Item No. **Report of the Head of Planning, Transportation and Regeneration**

Address 63-65 STATION ROAD HAYES

Development: First floor rear extension and conversion of storage area to a studio flat

LBH Ref Nos: **18175/APP/2020/2157**

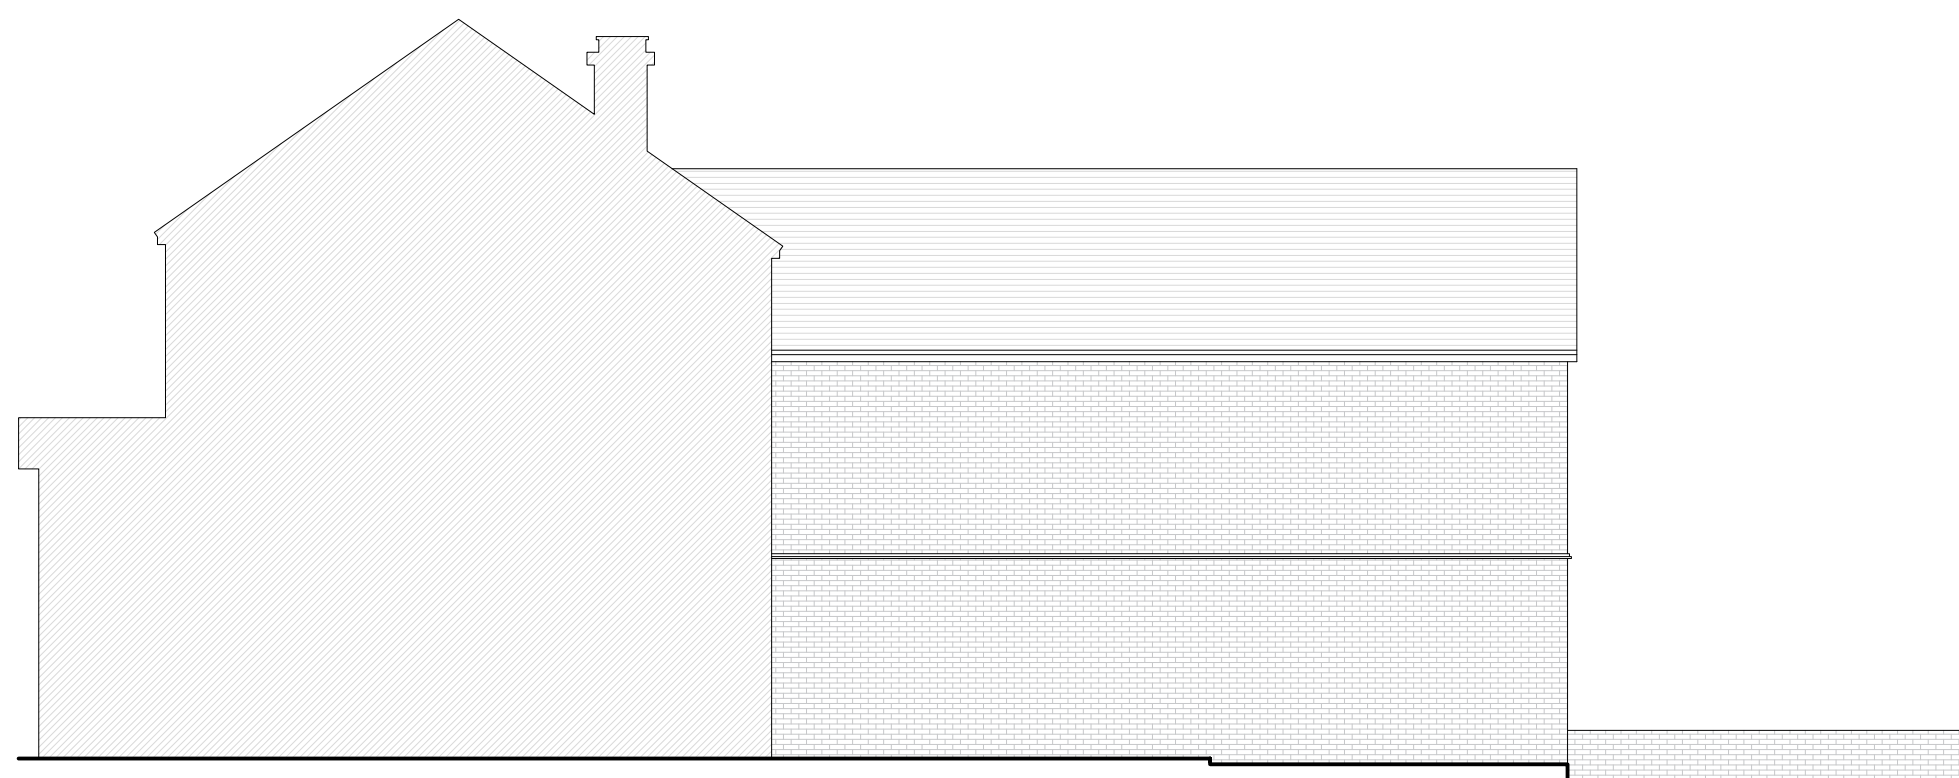
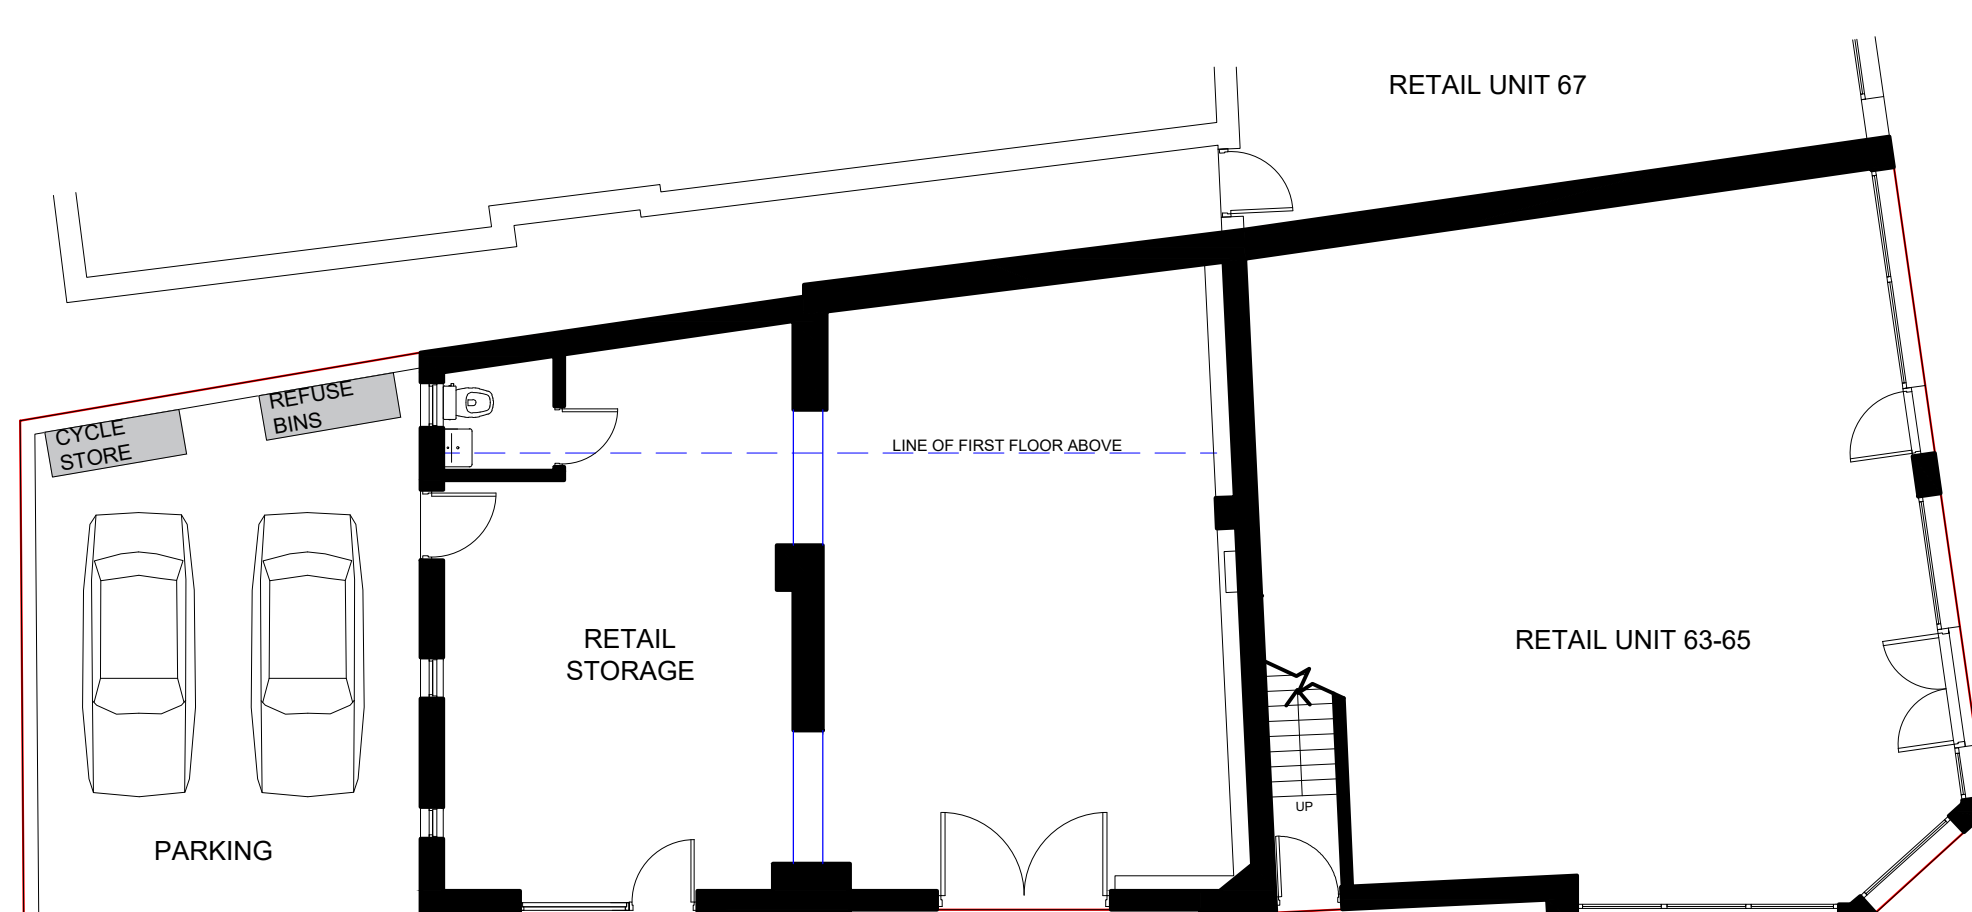
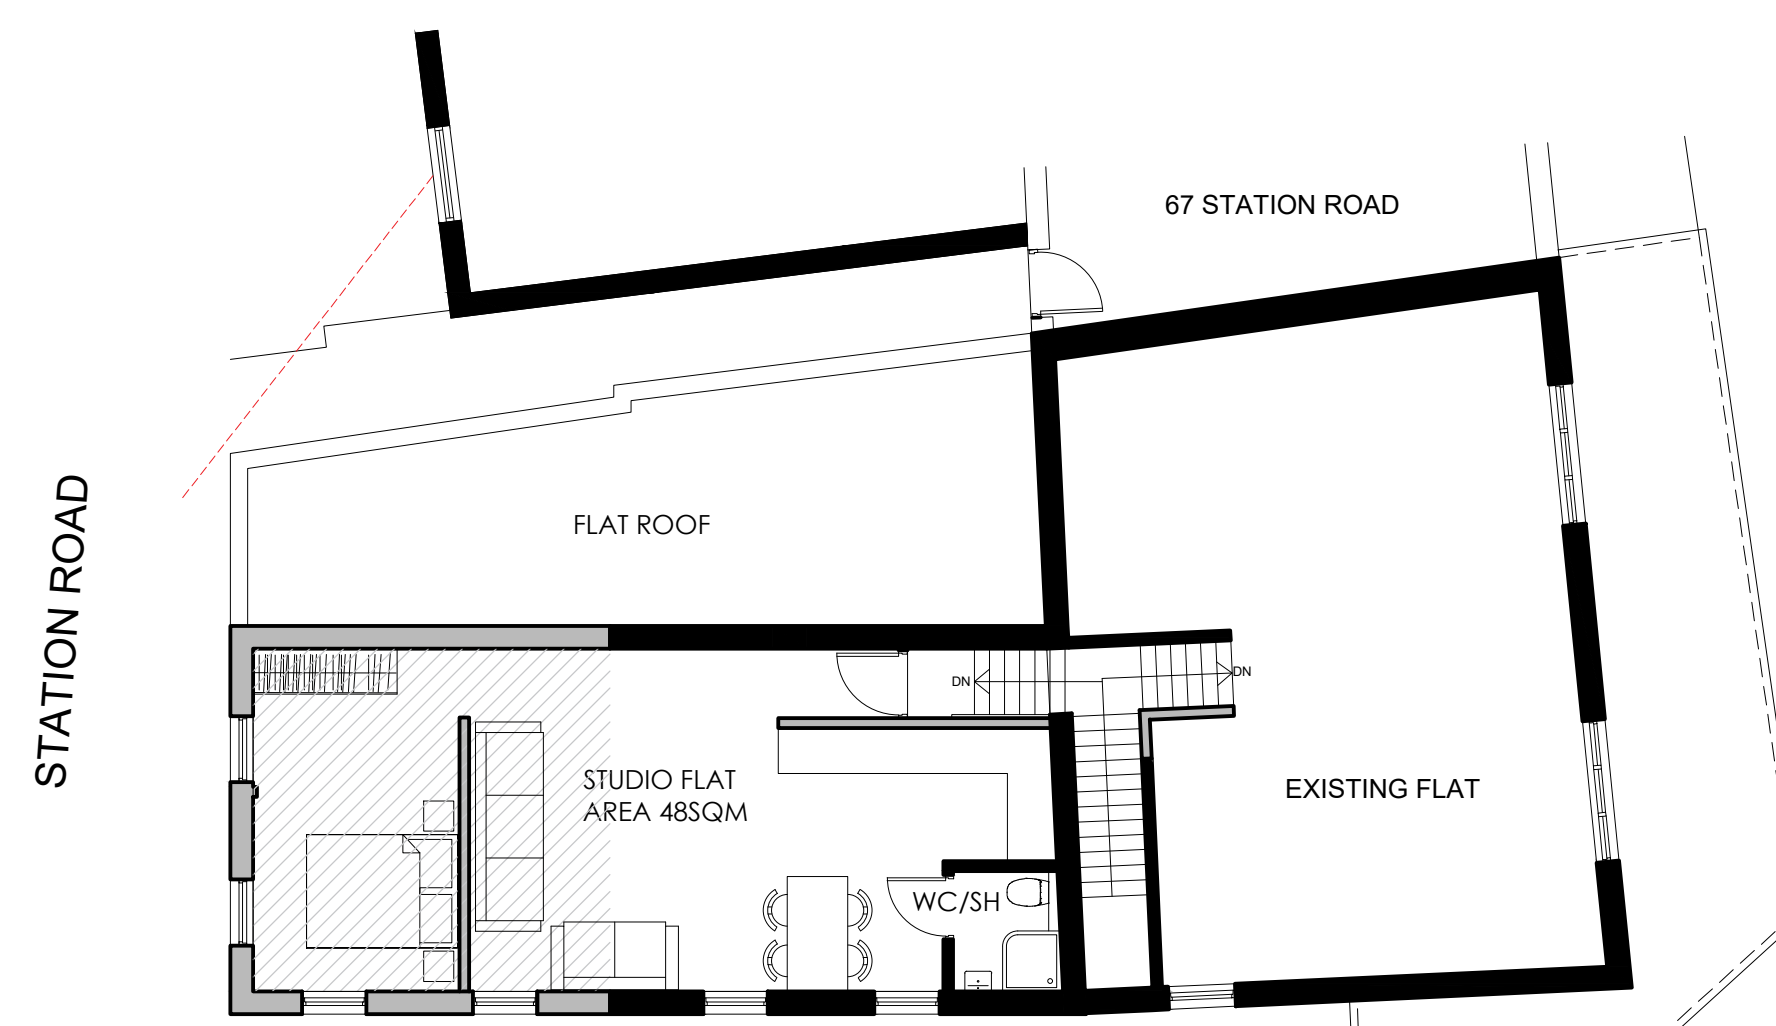
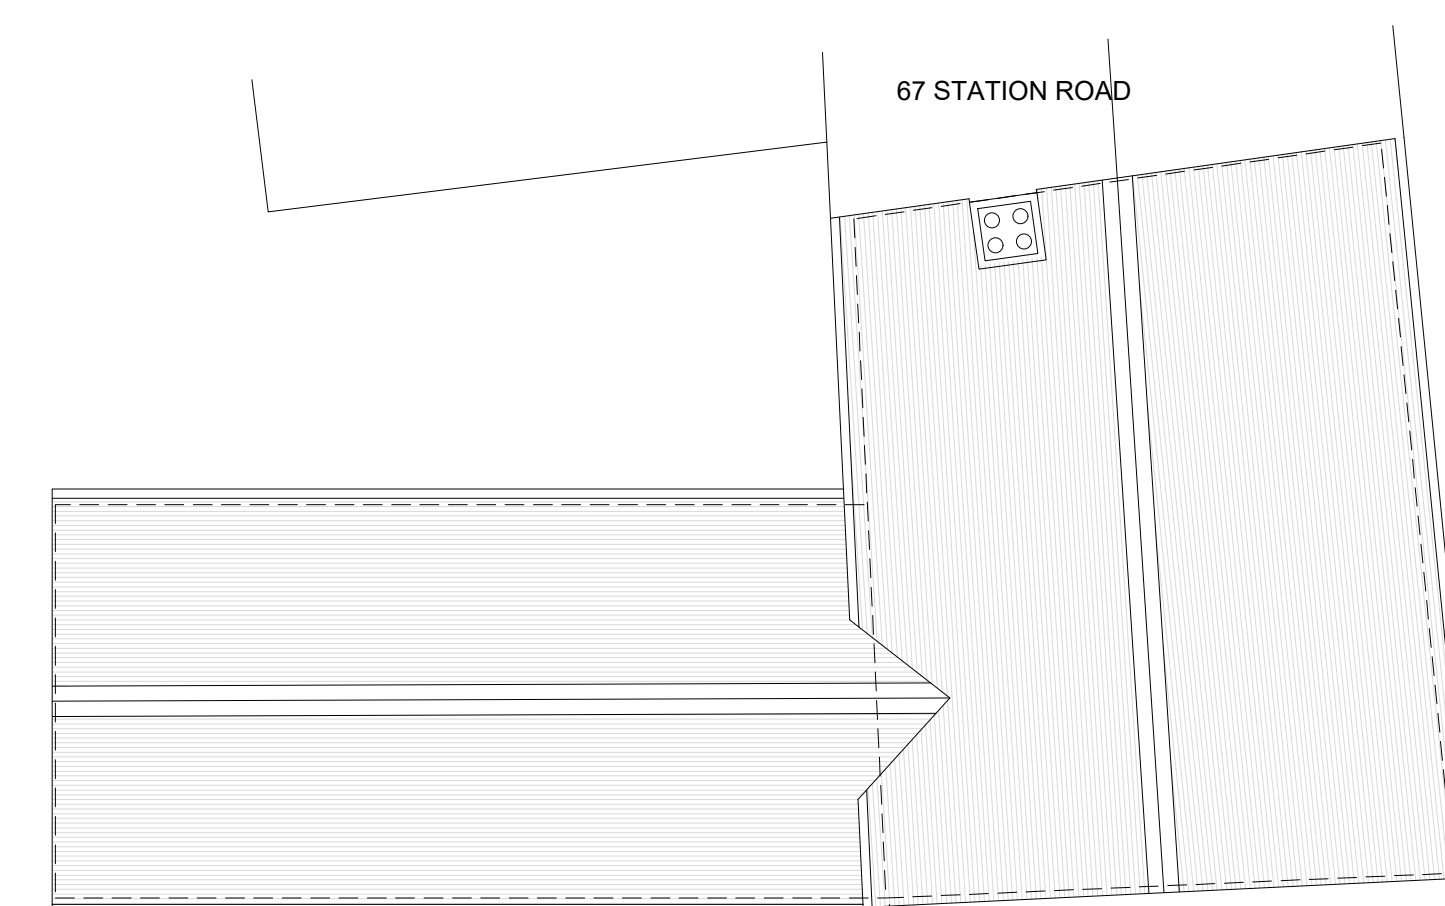
The current proposal does not include a terrace and the dormer extension has been removed. Whilst this does remove two concerns raised by the Inspector, it does not fully address the concern that the proposal would result in an over-dominant and visually obtrusive form of development in relation to the occupants of the first floor flat at 67 Station Road thereby causing a material loss of outlook for these adjoining occupiers. The overall bulk of the extension in terms of its footprint and roof is similar to that considered recently under refused scheme application reference 18175/APP/2020/544. The extension has been reduced in width, but the projection remains the same. It is considered that the increased projection of the first floor would remain unacceptably dominating on the outlook of the first floor flat at Number 67 Station Road.

The proposed development therefore, by reason of its overall siting, size, and bulk would result in an overdominant and visually obtrusive form of development in relation to the existing adjoining occupiers of the first floor flat at 67 Station Road and as such would constitute an un-neighbourly form of development, resulting in a material loss of residential amenity. The proposal is therefore contrary to Policies DMHB11 and DMHD1 of the Hillingdon Local Plan - Part Two (2020).

The application site occupies a prominent corner location with the rear and side elevations appearing prominent within the streetscene. This current proposal removes the unacceptable crown roof element and dormer extensions of the previous proposal which was dismissed at appeal and reduced the width of the extension that was recently refused. The extension is designed to be subordinate in height to the existing main building and, whilst it elongates the plan form, it is considered that the proposed extension would respect the architectural integrity of the host building and would not detract from the visual amenities of the street scene.
